OBJECTION

State Significant Development Application No: SSD-10300

Coffs Harbour Cultural and Civic Space

GORDON ST ELEVATION

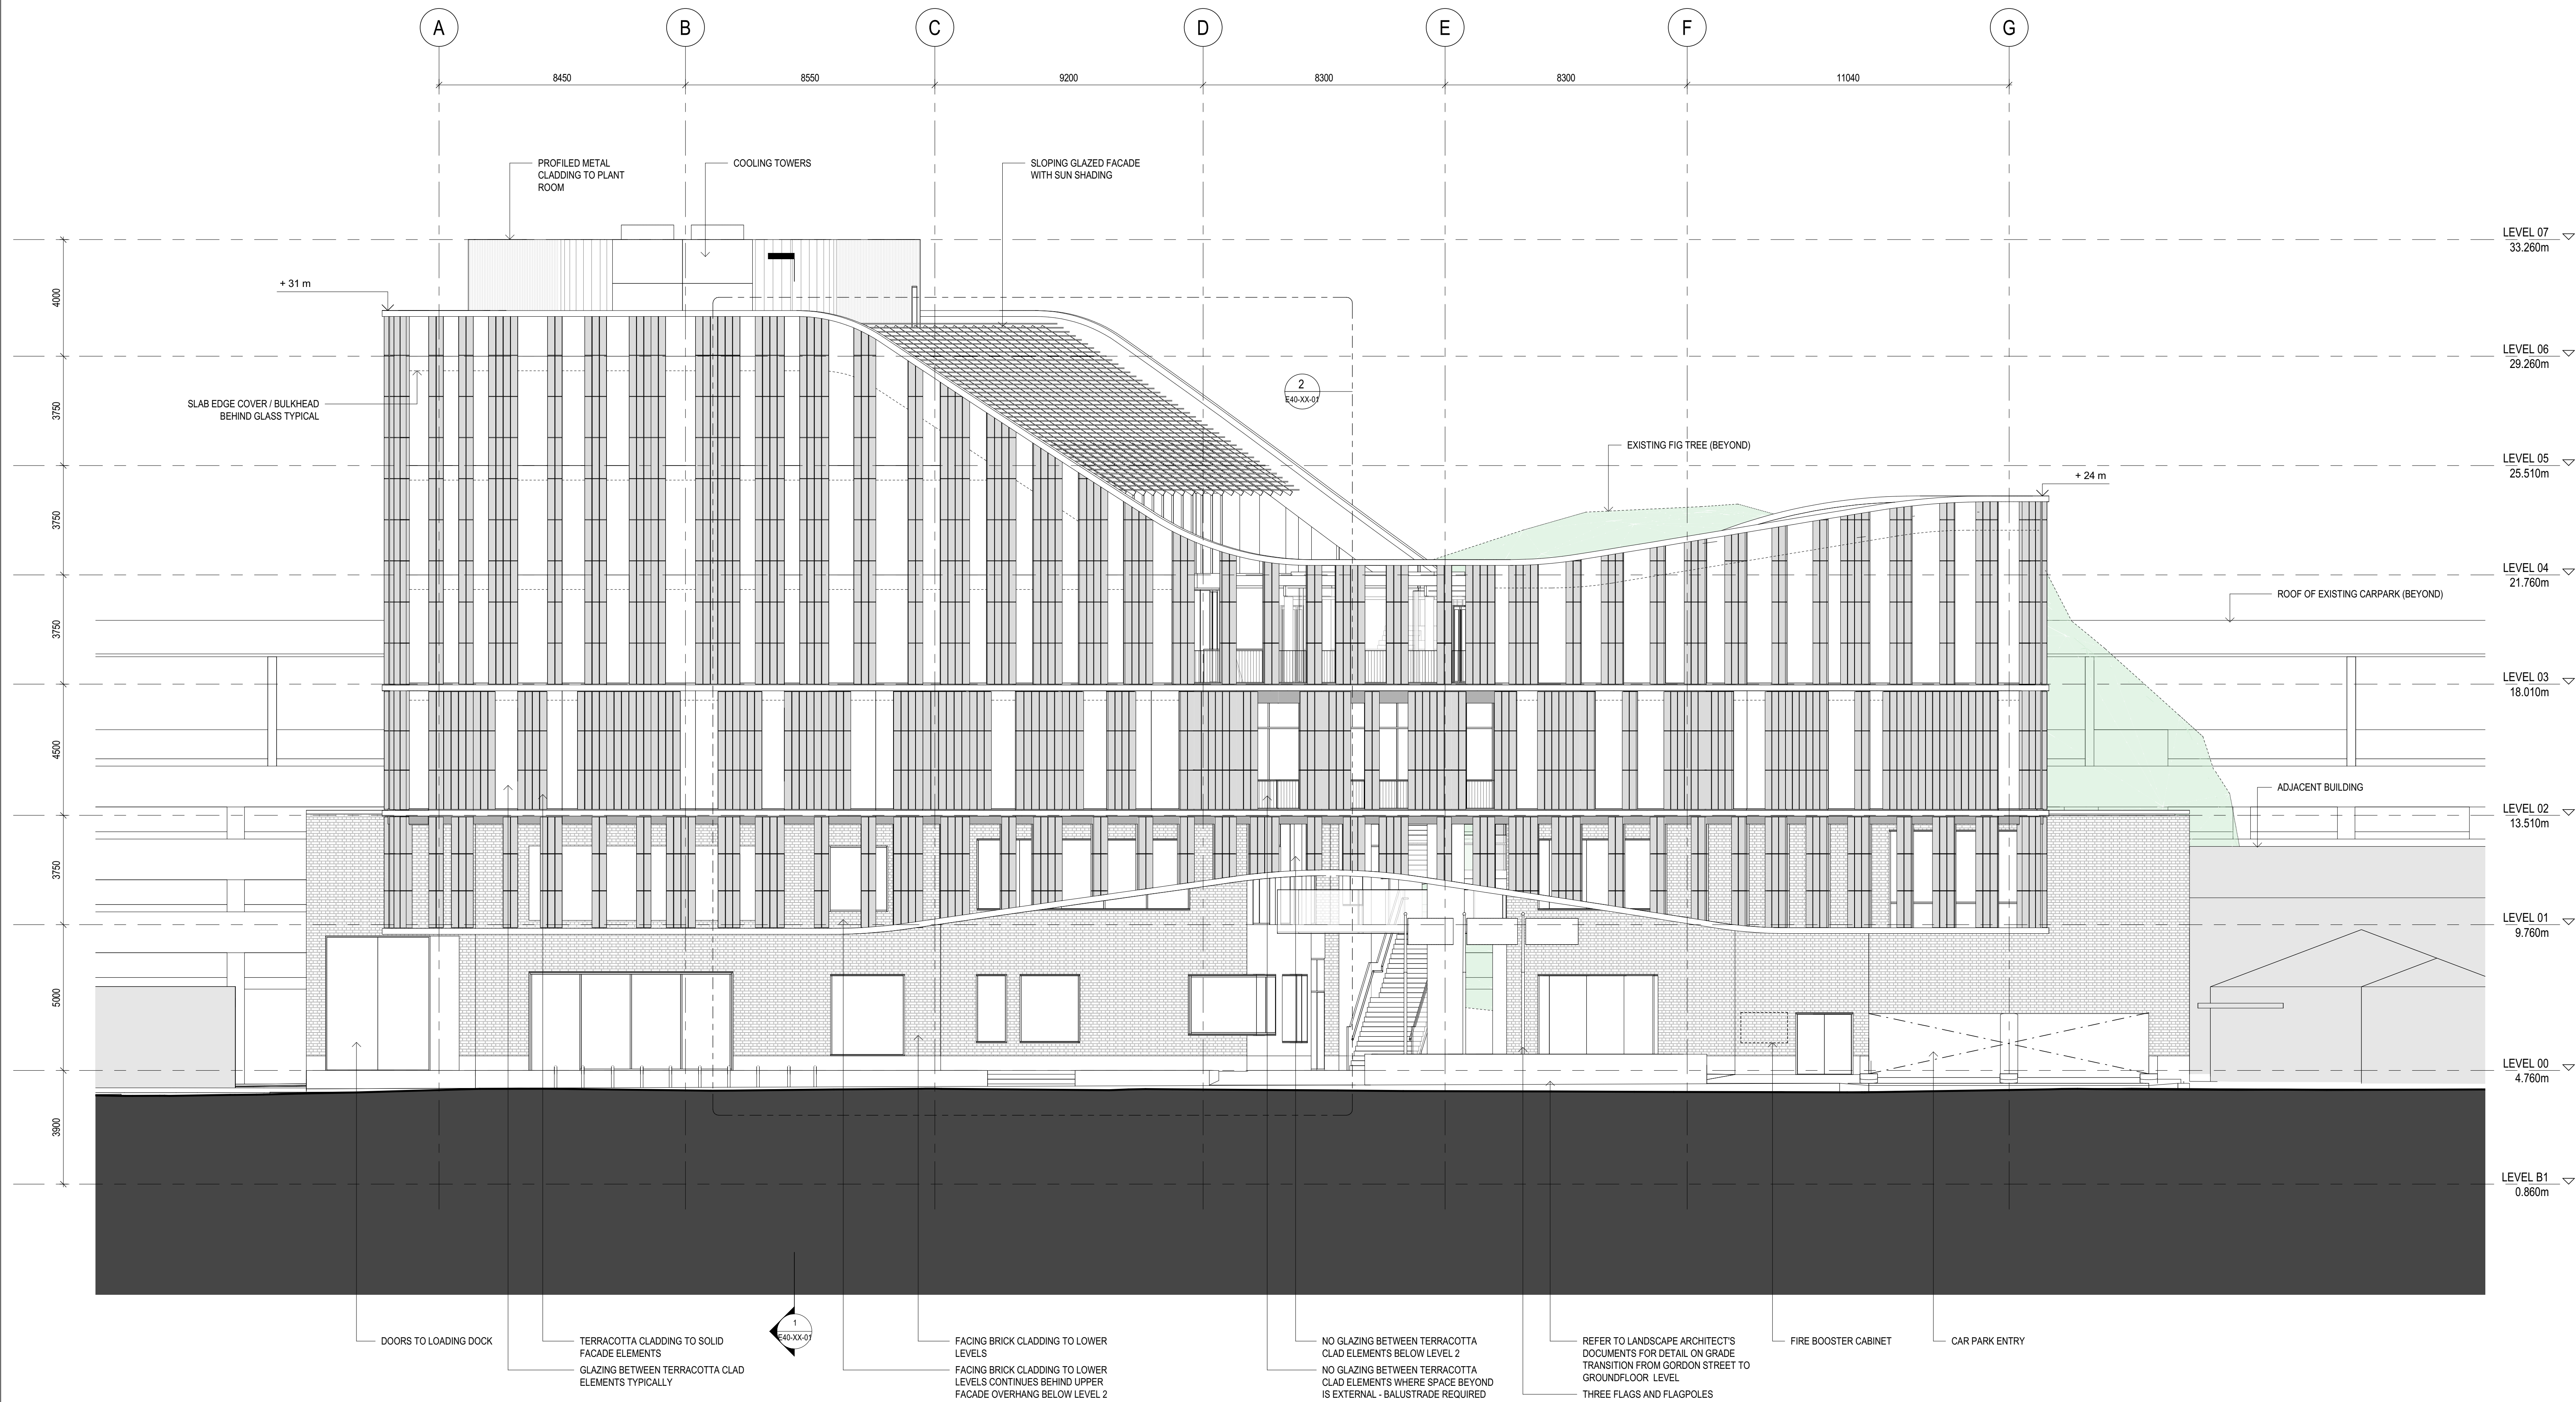
5. The proposed building is out of context in the street with no regard to scale, existing street setbacks, design and general form of adjoining buildings.

RIDING LANE ELEVATION

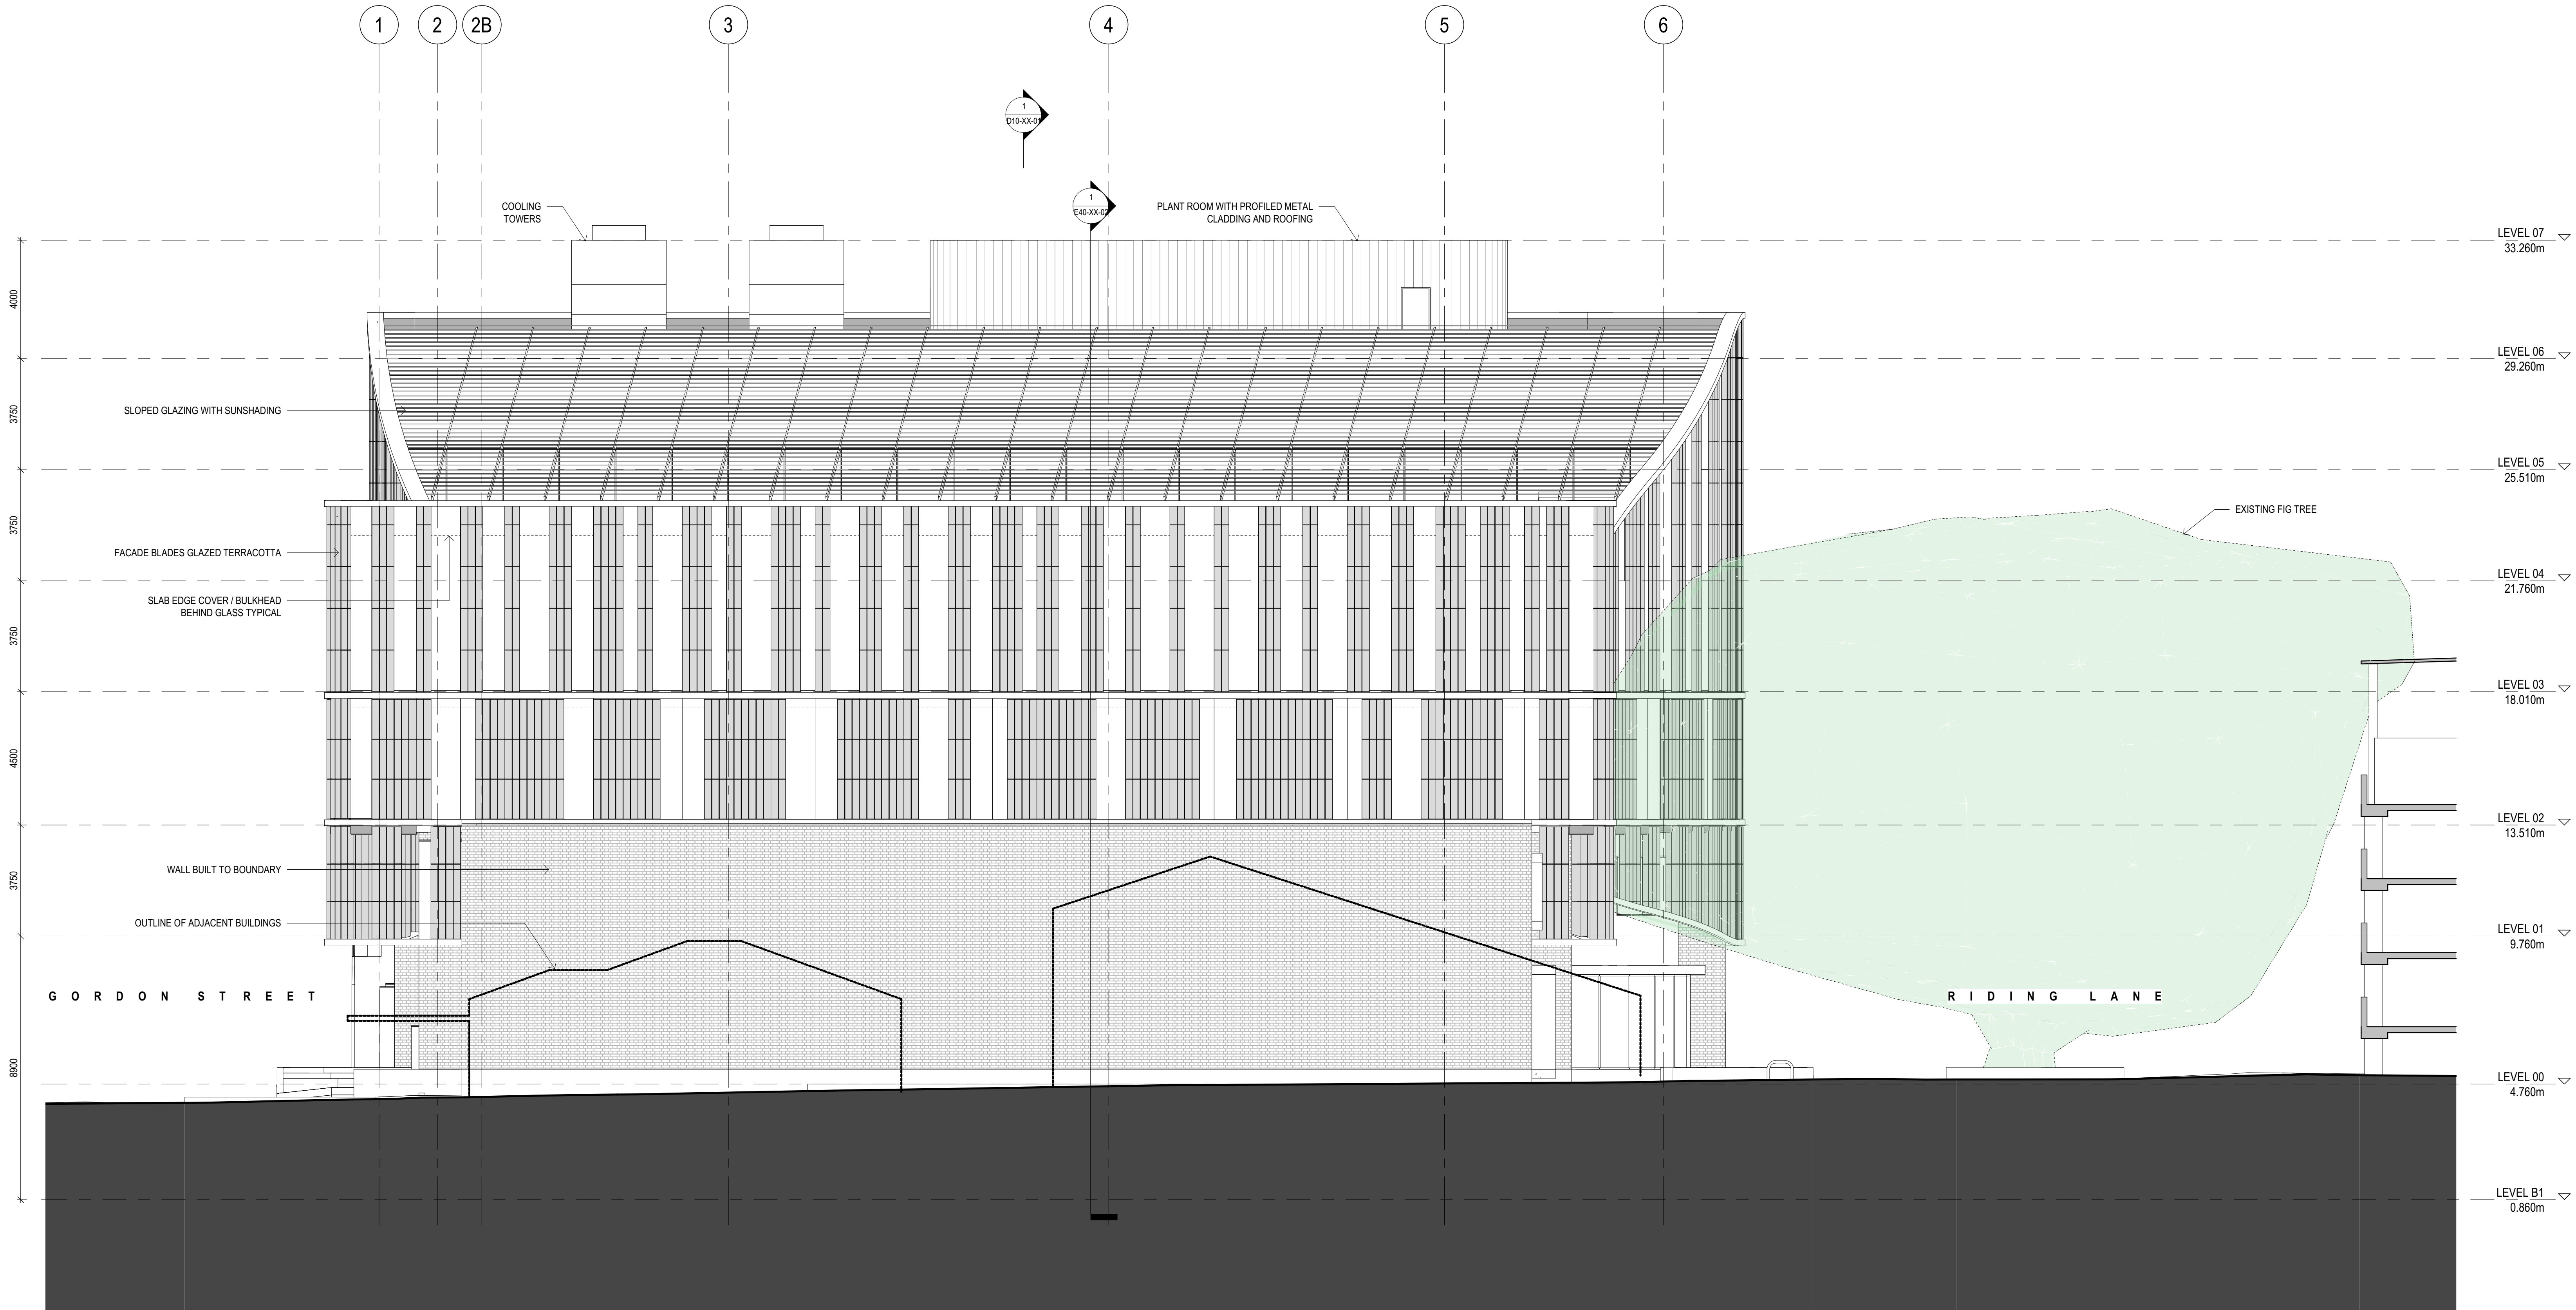
6. The proposal does not meet "safer by design" principles and guidelines, as the arcade to Riding Lane confuses boundaries and provides "hides" for criminal activity, vagrancy and prevents good surveillance.

SECTION N-S

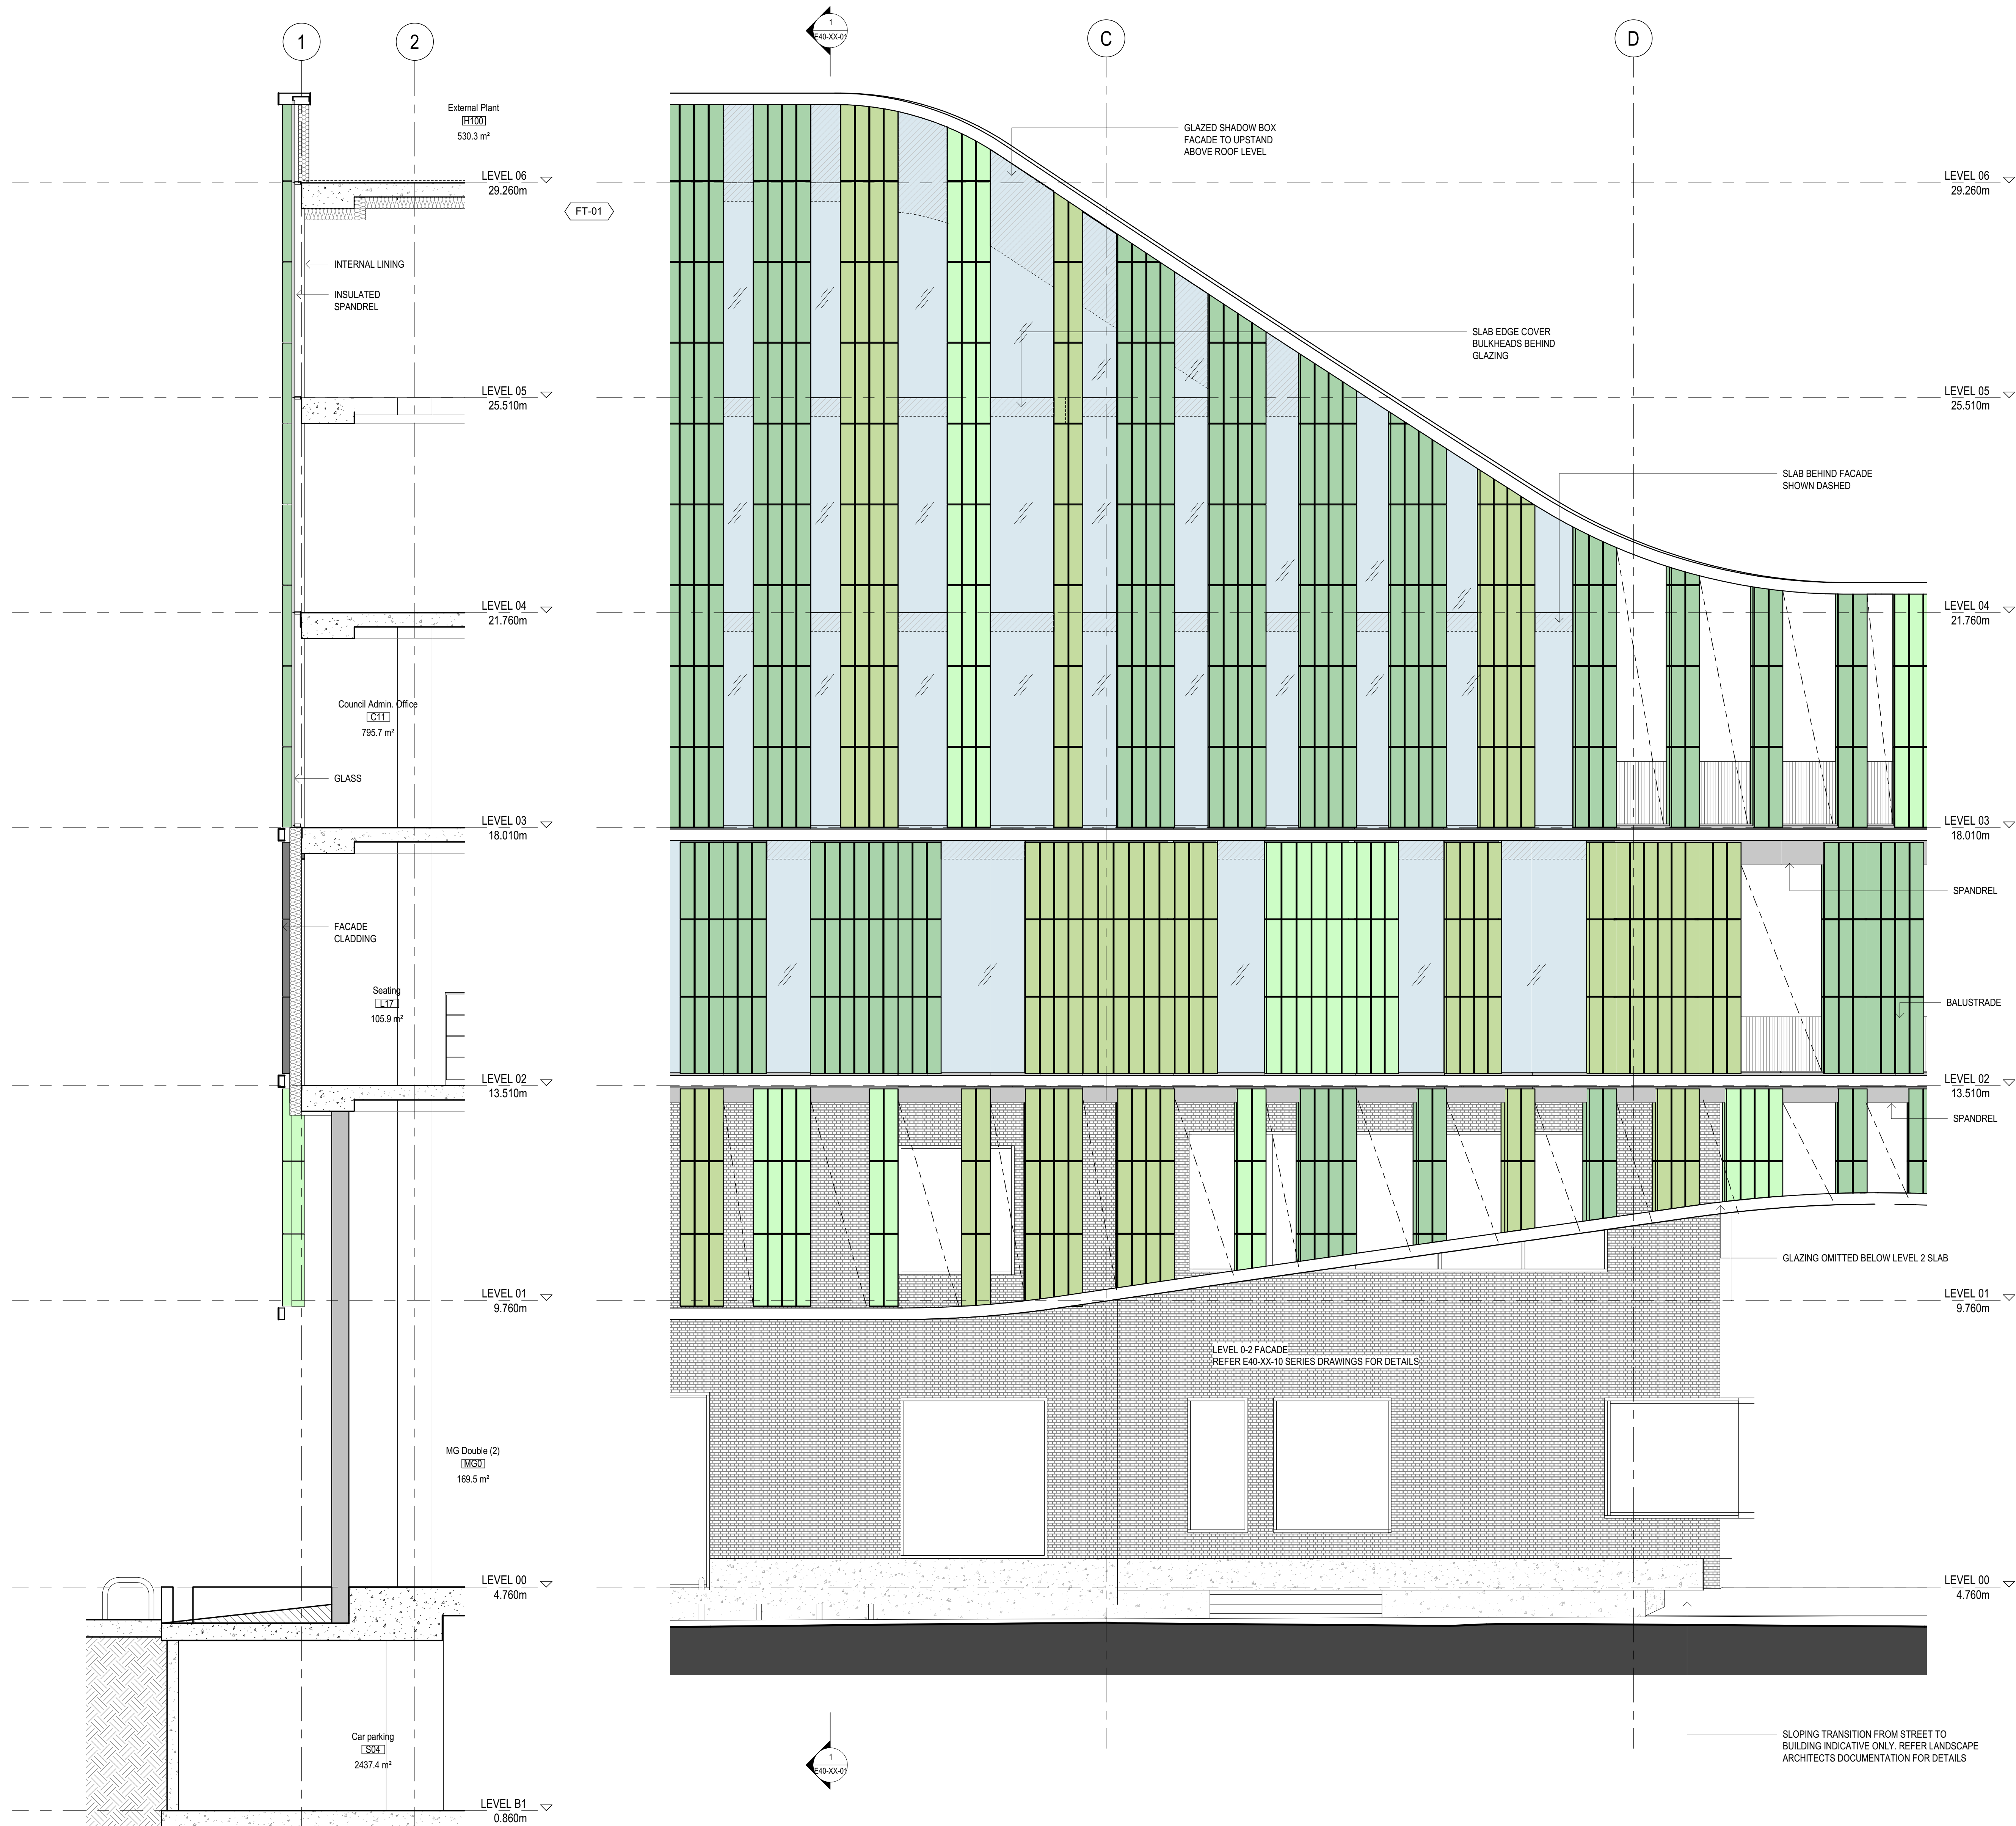
7. As a public building it fails to provide sufficient climate protection for pedestrians during storms and summer sun.
8. The building exceeds the height restriction of 28m set down in Council's own planning controls. Council's argument for variation is not satisfactorily justified and is not consistent with the objectives of the Environmental Planning and Assessment Act 1979, which requires the "the orderly and economic use and development of land". Council should not receive preferential treatment.
